PLANNING CONSULTATION RESPONSE

Application No	<u>2026/0443</u>
Proposal	Demolish existing rear single storey extension and erection of 2 storey extension and formation of off street parking spaces.
Address	170 Sheffield Road, Birdwell, Barnsley, S70 5TD
Date of Consultation Reply	03/07/26
Consultee	Highways Development Control

Proposed Site Layout  
Scale 1:250

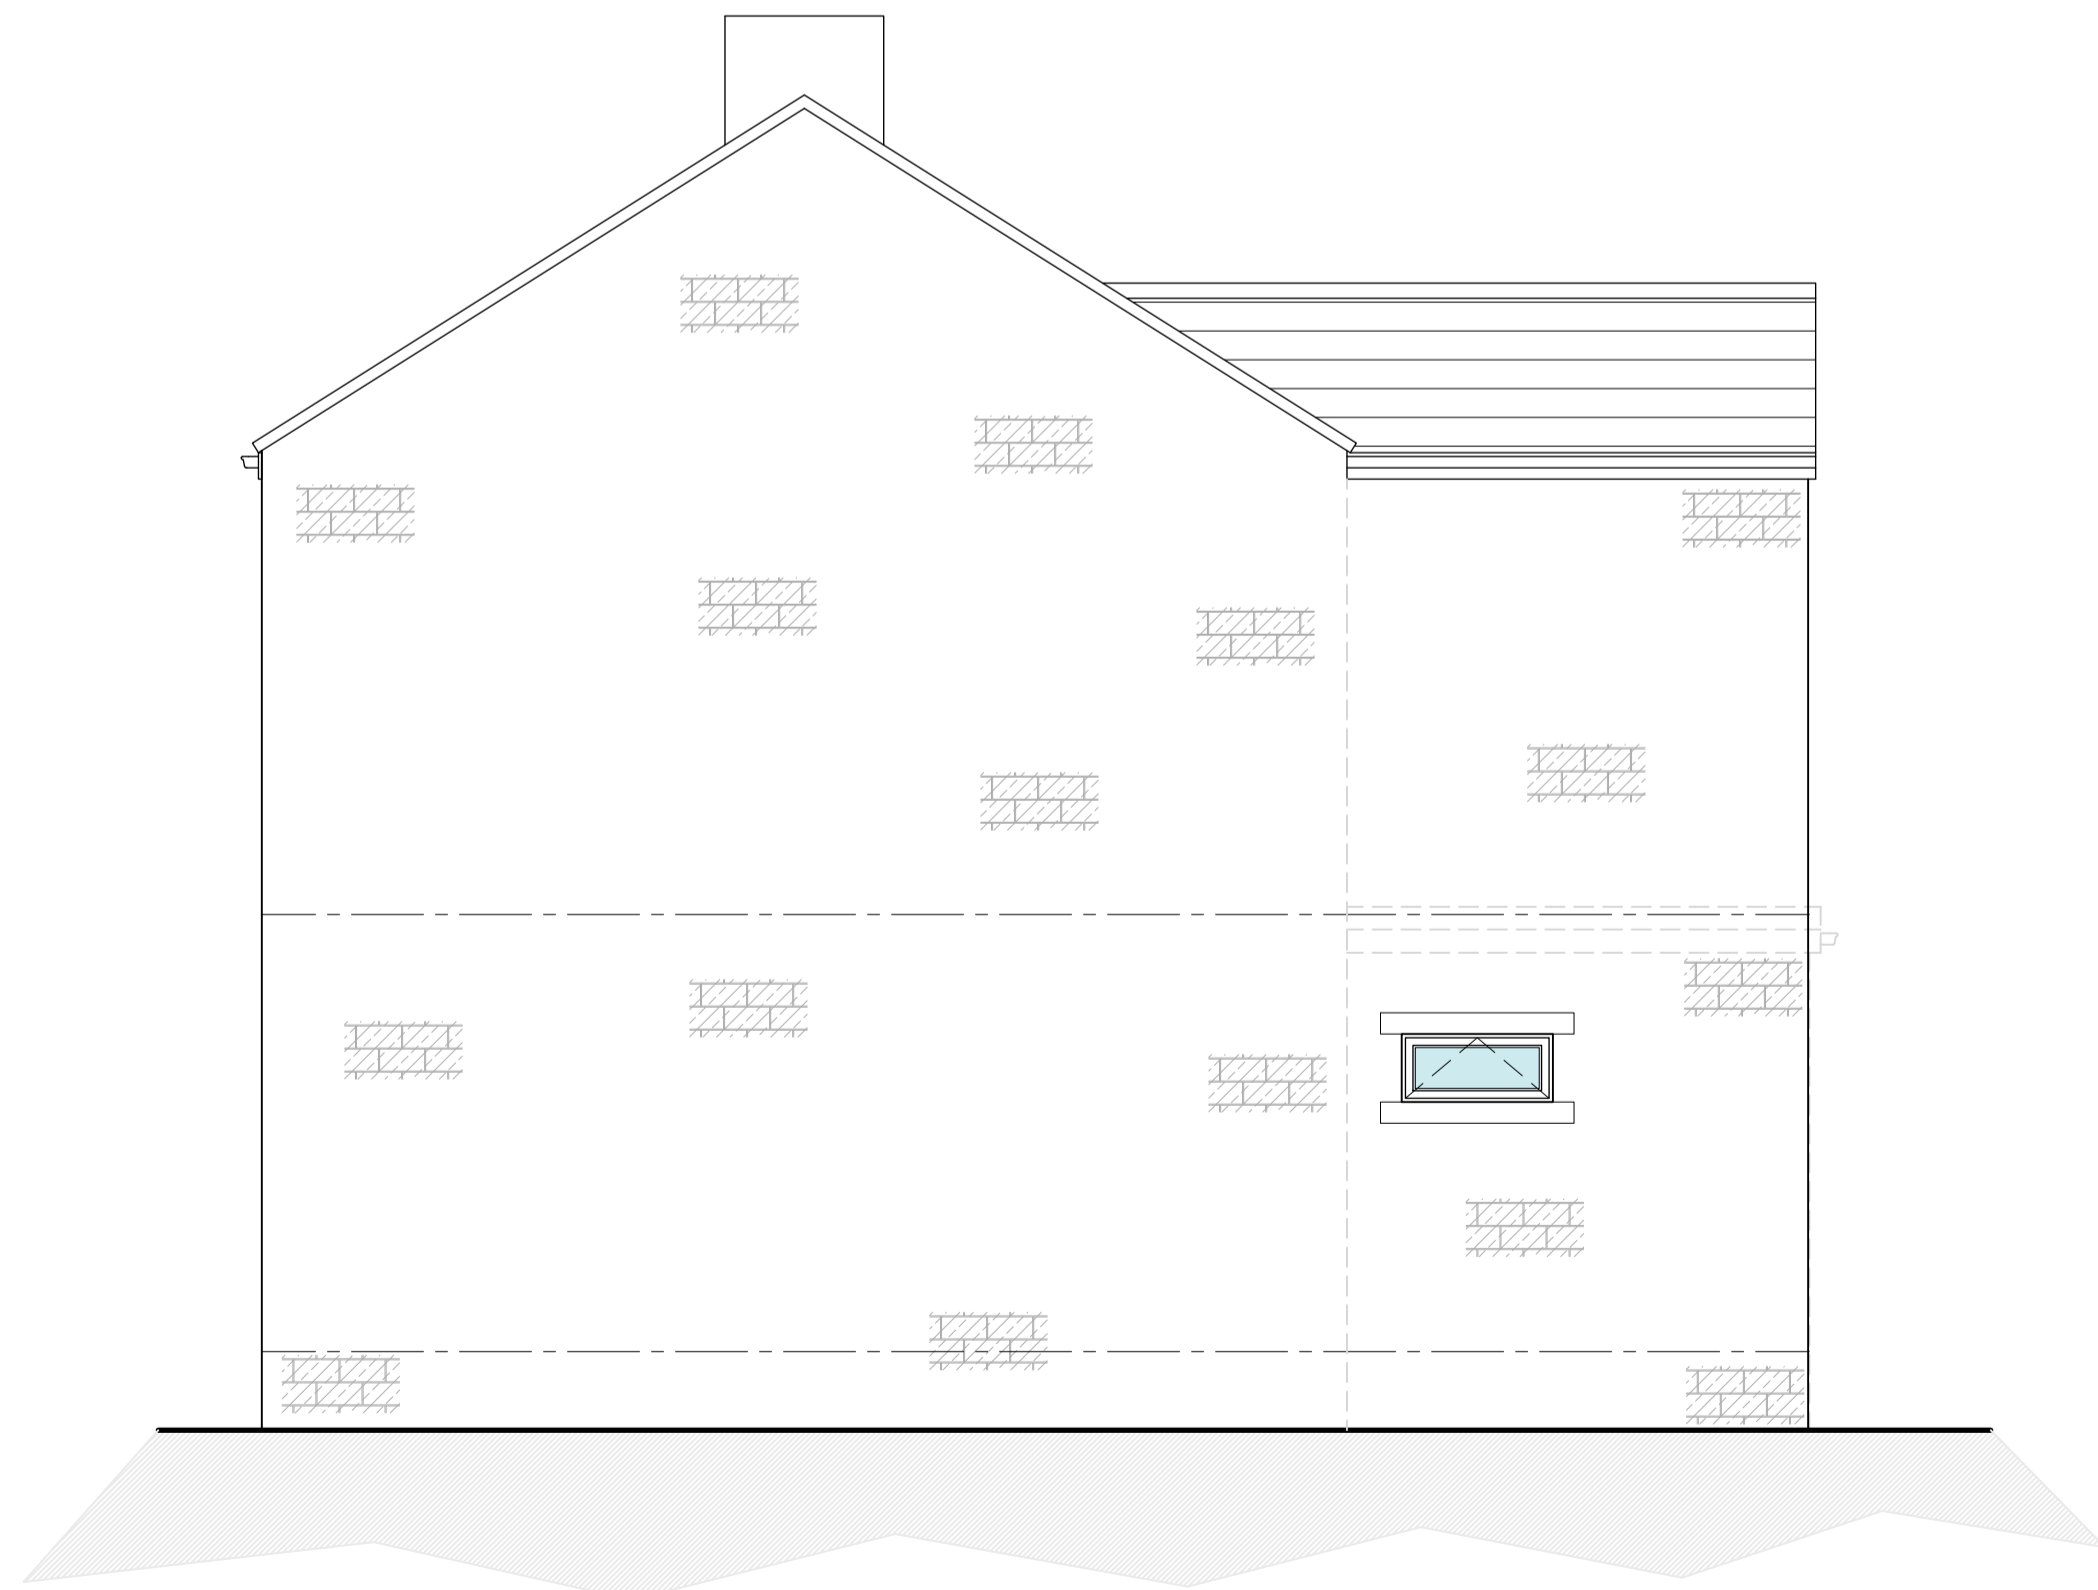
Having reviewed the submitted information, I note that the proposed off street parking spaces would be accessed from the existing rear access serving the properties fronting Sheffield Road. The rear access appears to provide access and egress in both directions and, as such, vehicles would not be required to reverse out onto Sheffield Road.

The proposed parking spaces are shown at 2.5m wide by 10m long, forming a tandem parking arrangement. On this basis, I am satisfied that the spaces are of sufficient size to accommodate two vehicles within the site, without overhanging the rear access.

As such, I have no objections to application subject to the parking spaces being appropriately constructed and surfaced as detailed in the attached condition below.

Before the development is brought into use, that part of the site to be used by vehicles shall be surfaced in a bound, solid material and adequate measures shall be so designed into the proposed access to avoid the discharge of surface water from the site on to the highway.
Reason: To ensure adequate provision for the disposal of surface water and to prevent mud/debris from being deposited on the public highway and to prevent the migration of loose material on to the public highway to the detriment of road safety.
